FAO: Planning Department,
Welwyn Hatfield Borough Council

Ref: 6/2021/1177/FULL
Date: 04/06/2021

HISTORIC BUILDINGS AND CONSERVATION ADVICE

RE: 52 & 54 Bridge Road, Welwyn Garden City, AL8 6UR

Project: RO Bridge Road, 52&54 AL8 6UR
Client: Mr. M. Tabrizi
Title: Proposed Site Plans and Elevation
Scale @ A1: As indicated
Drawing No: 1644.P.02

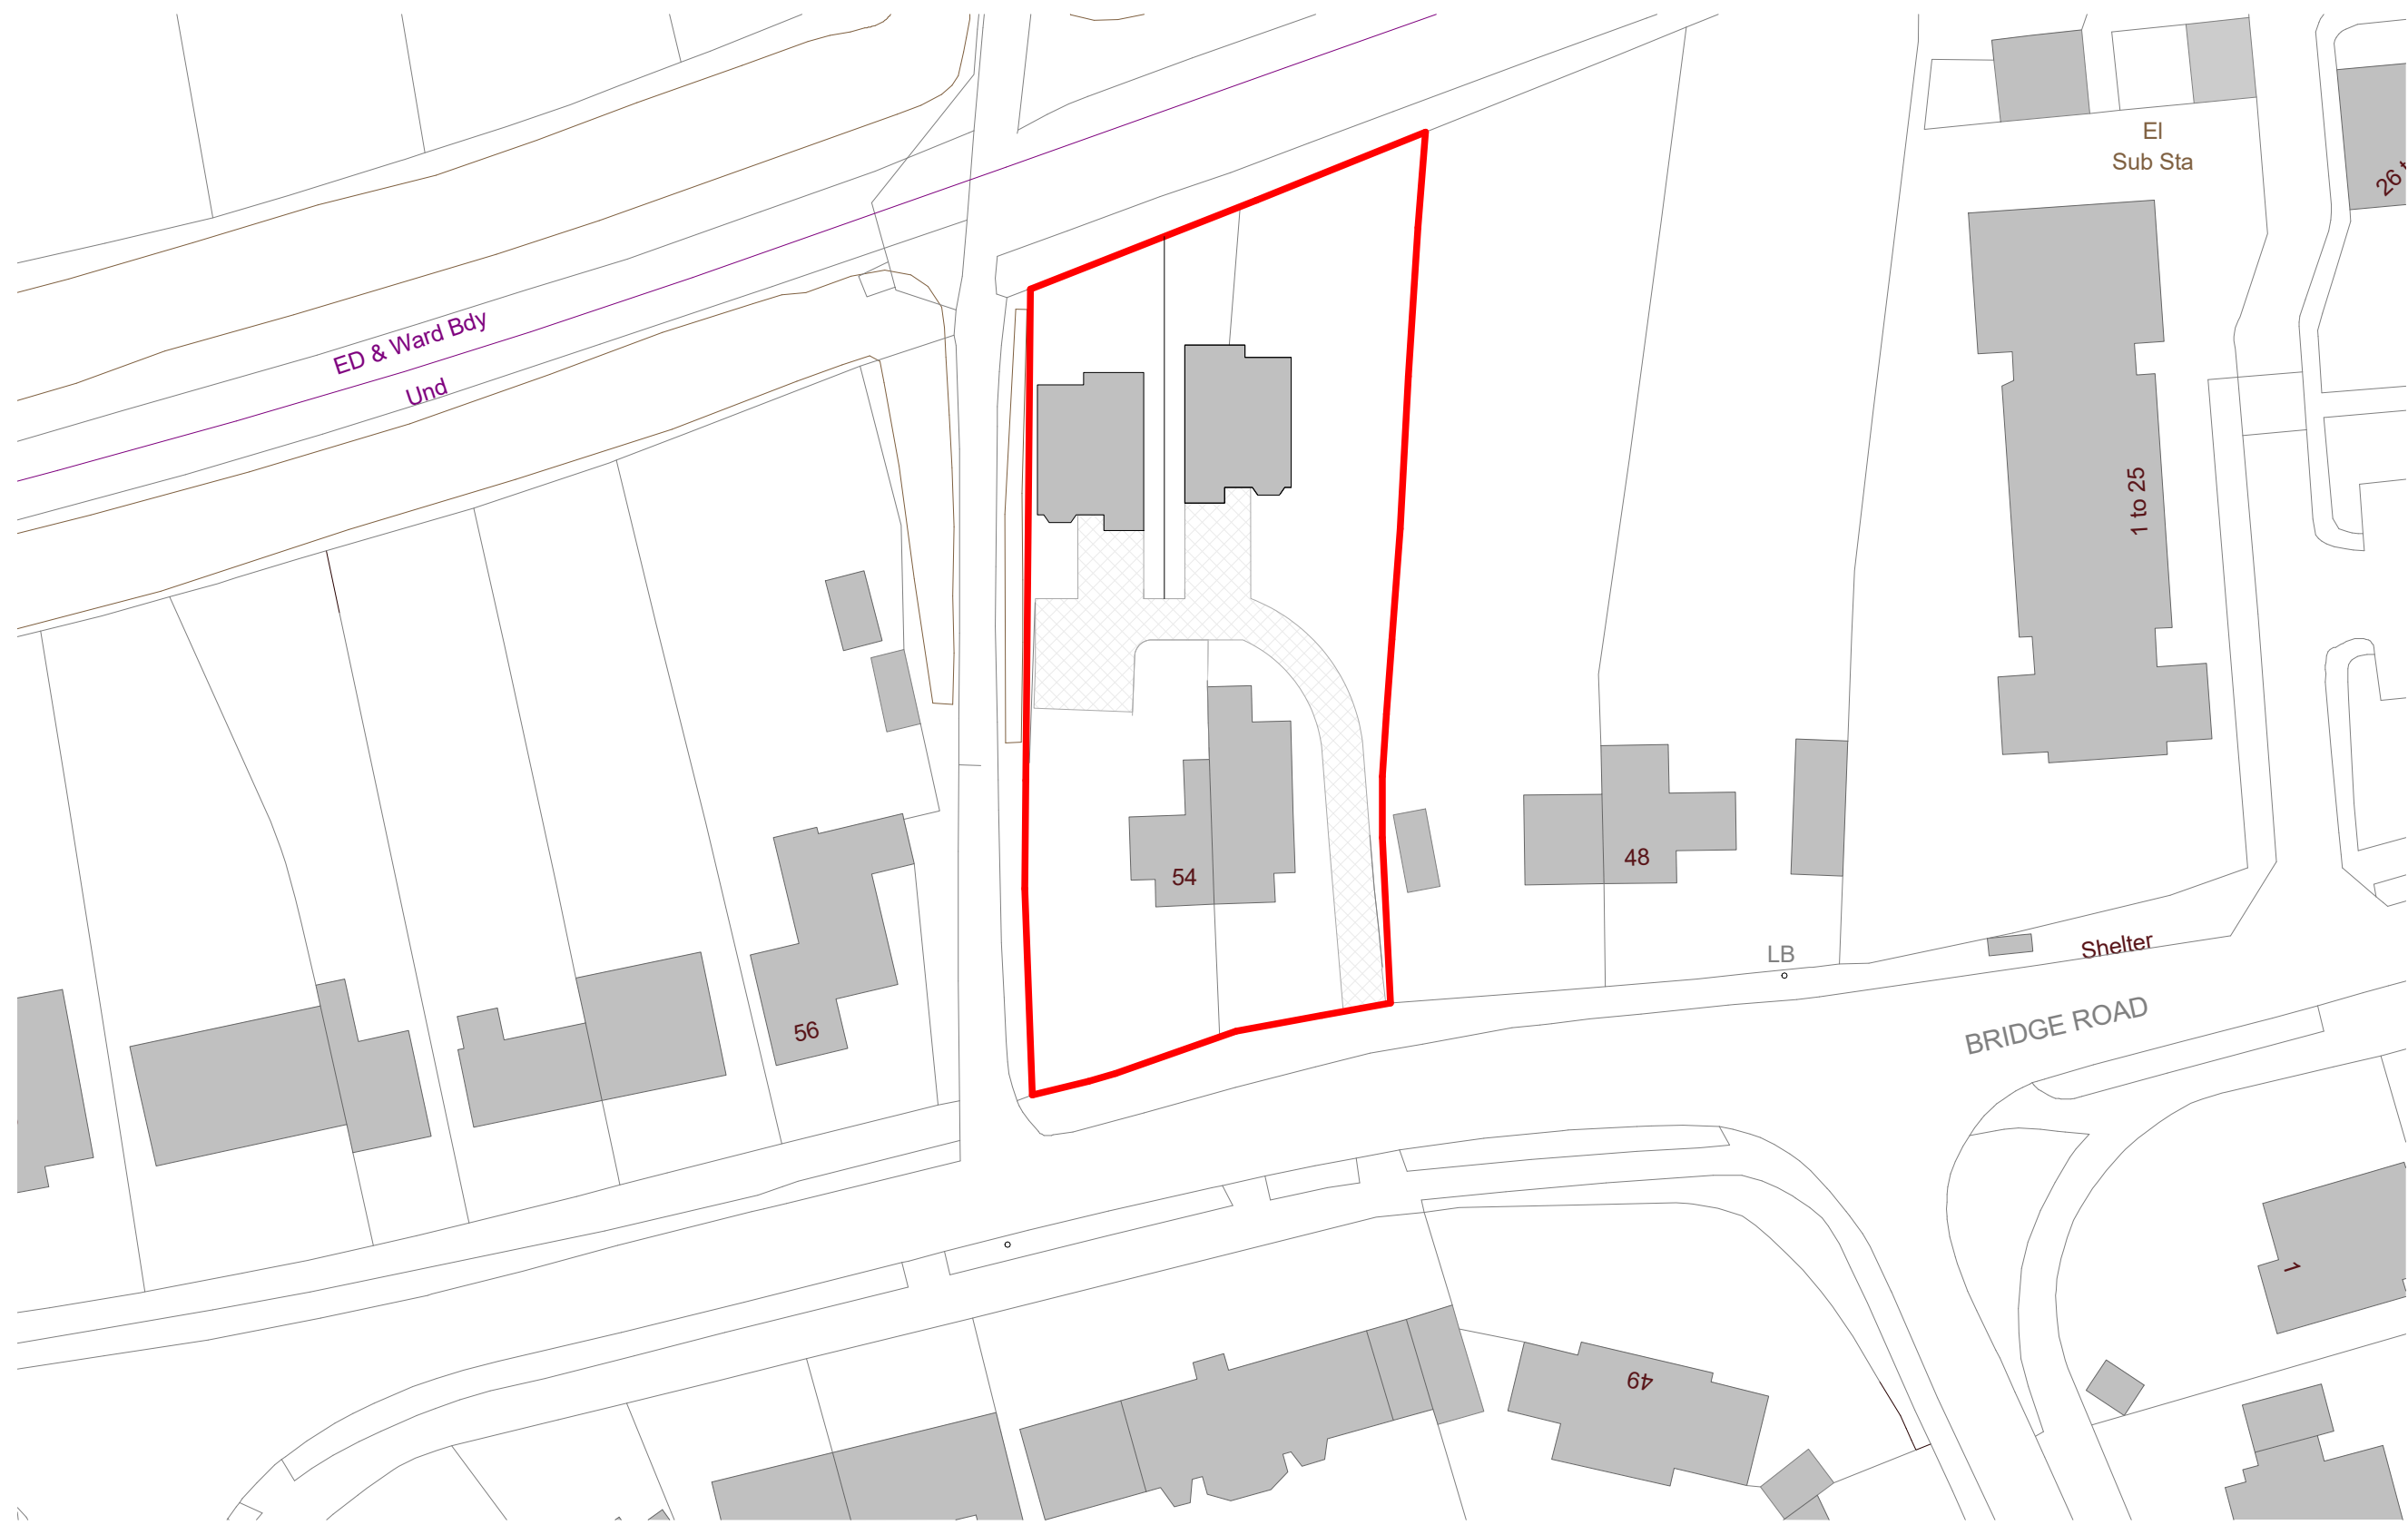
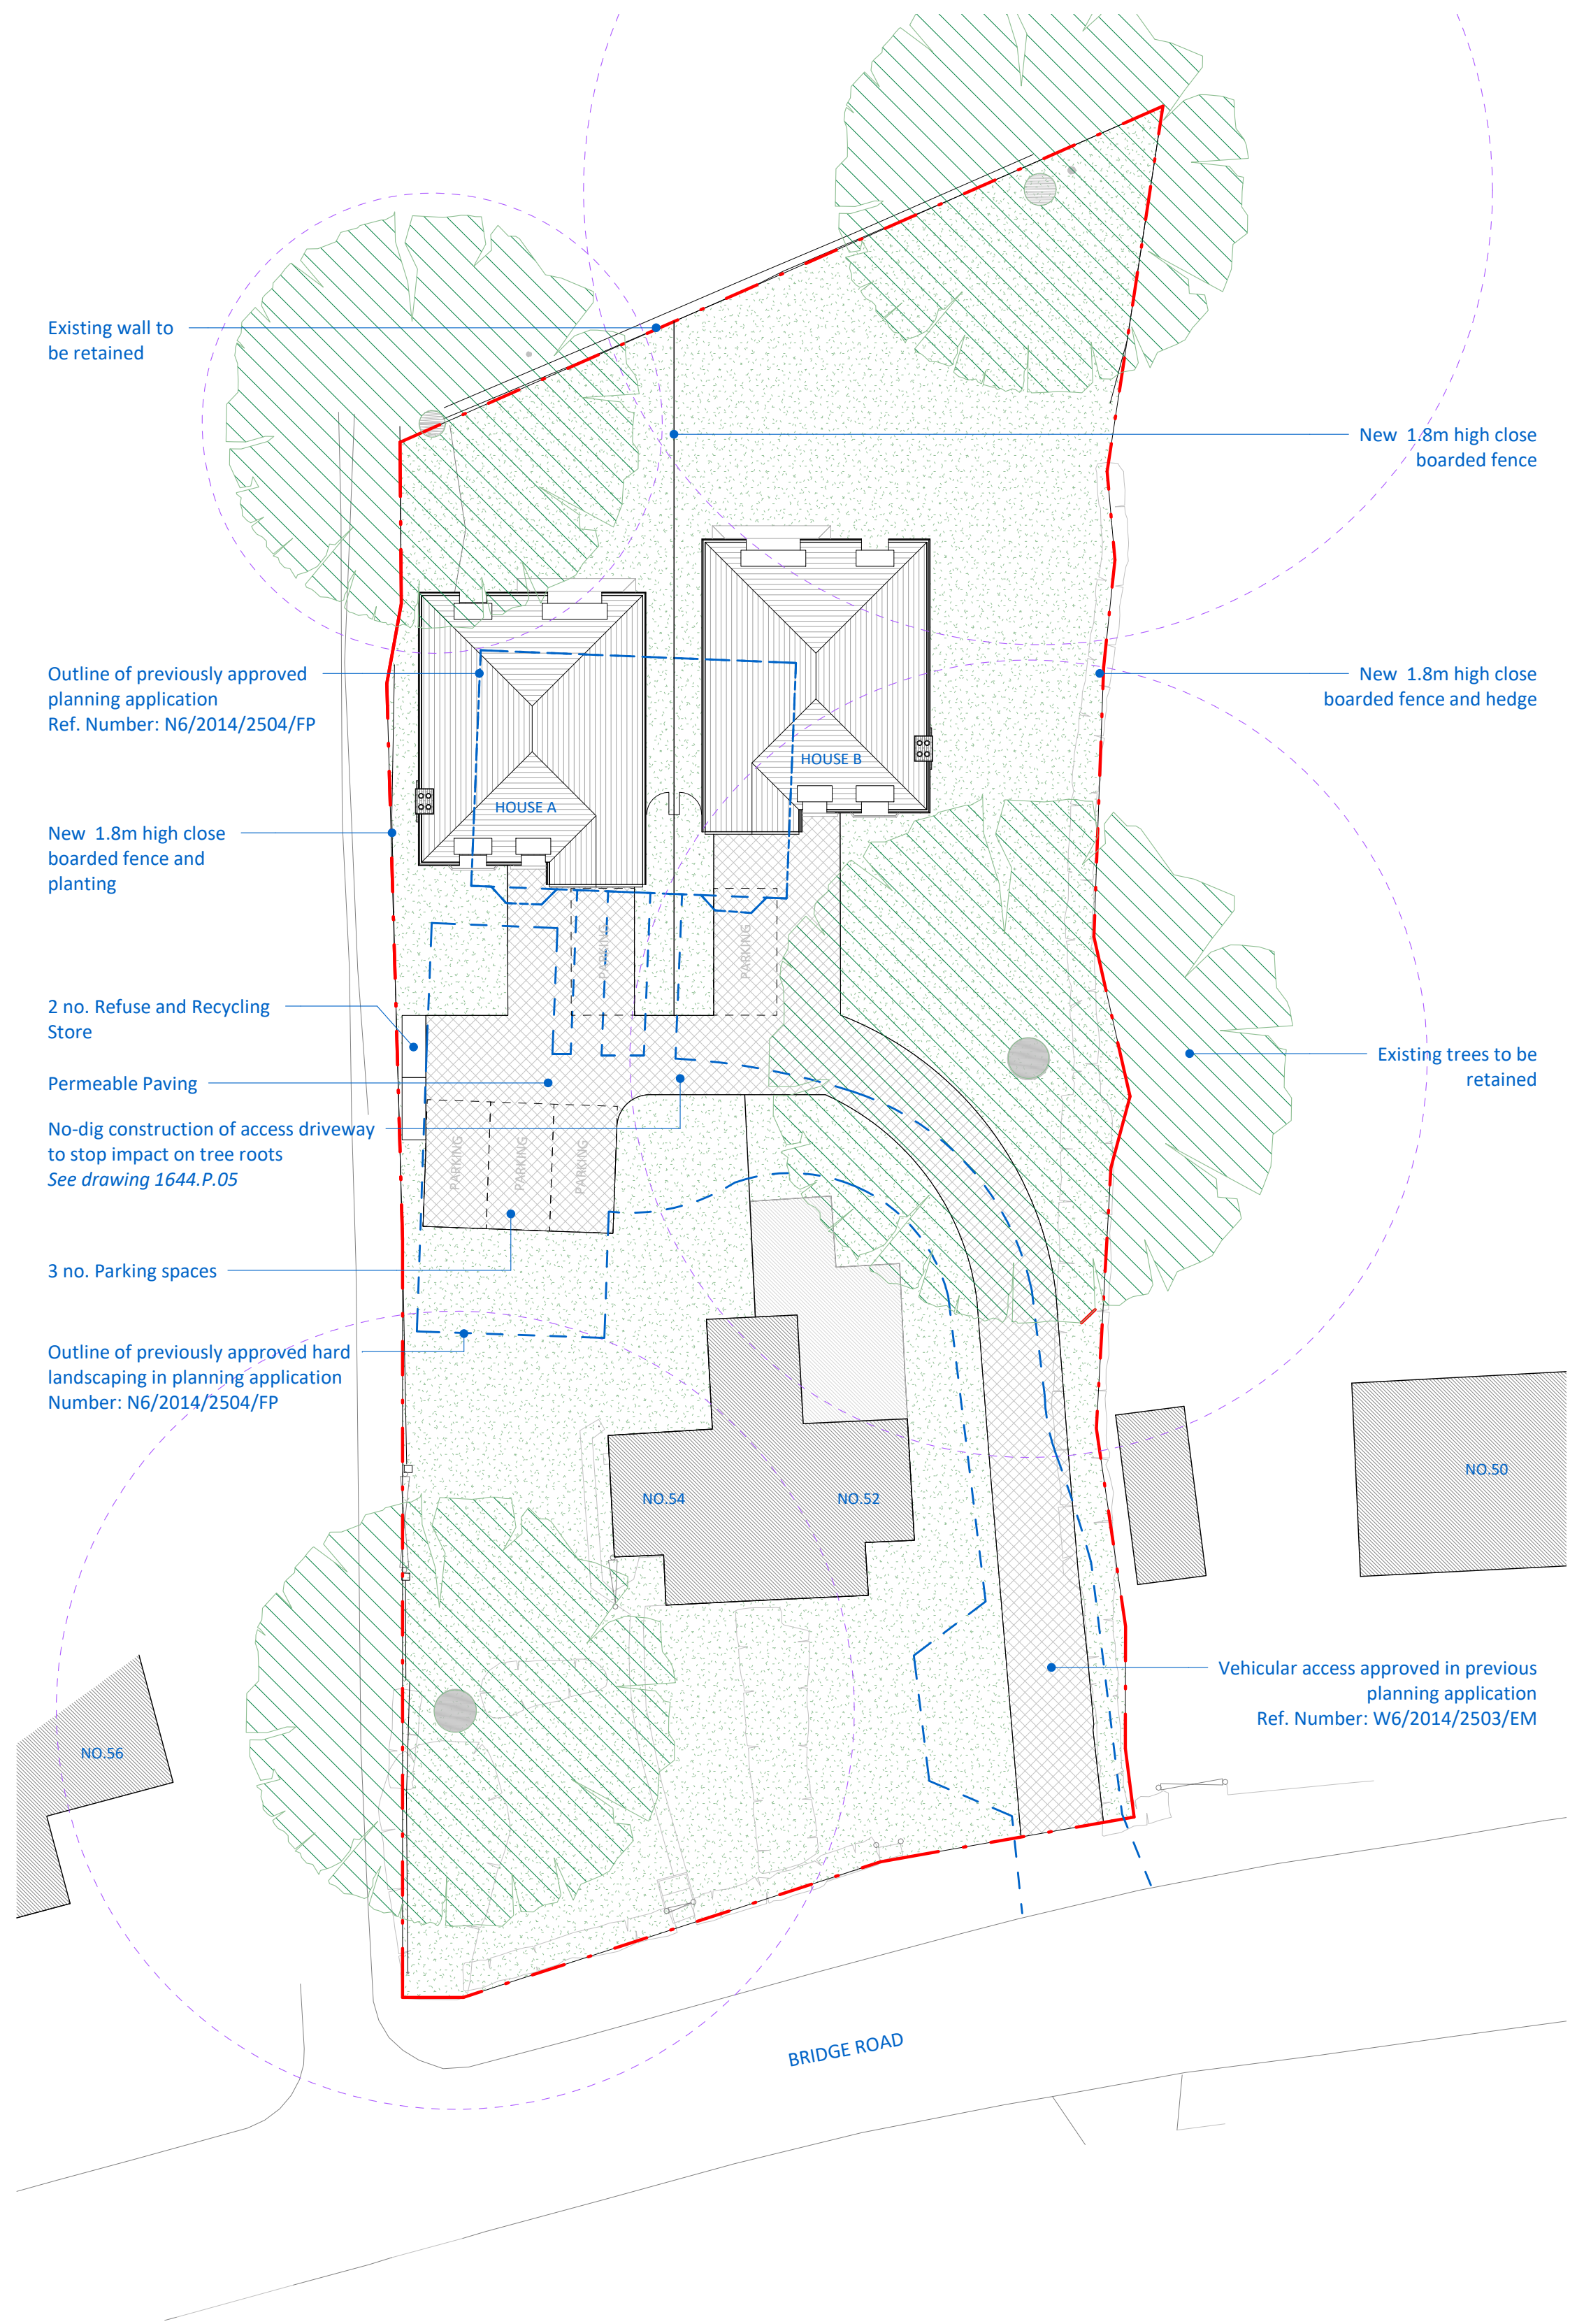
The proposal is a slight improvement on the withdrawn scheme 6/2020/3306/FULL due to the removal of the crown roofs to the proposed houses, but it remains less sympathetic than the previously proposed single dwelling behind no. 54 (6/2020/1837/FULL). Concerns similar to the previous scheme are raised below.

Historically, the land to the rear of nos. 52 & 54 was undeveloped and the houses of the Garden City were laid out in a linear pattern along the northern side of Bridge Road. The proposed dwellings are at odds with the prevailing linear development and impact on the setting of nos. 52 & 54 by infilling the undeveloped land between them and the pre-Garden City features of the former railway line and Sherrardspark Wood. The proposed houses are also larger than nos. 52 & 54.

The proposed dwellings would also undermine the verdant appearance of this part of the Conservation Area by obscuring views of the trees at the rear of the site along the footpath in views from Bridge Road as well as down the proposed driveway.
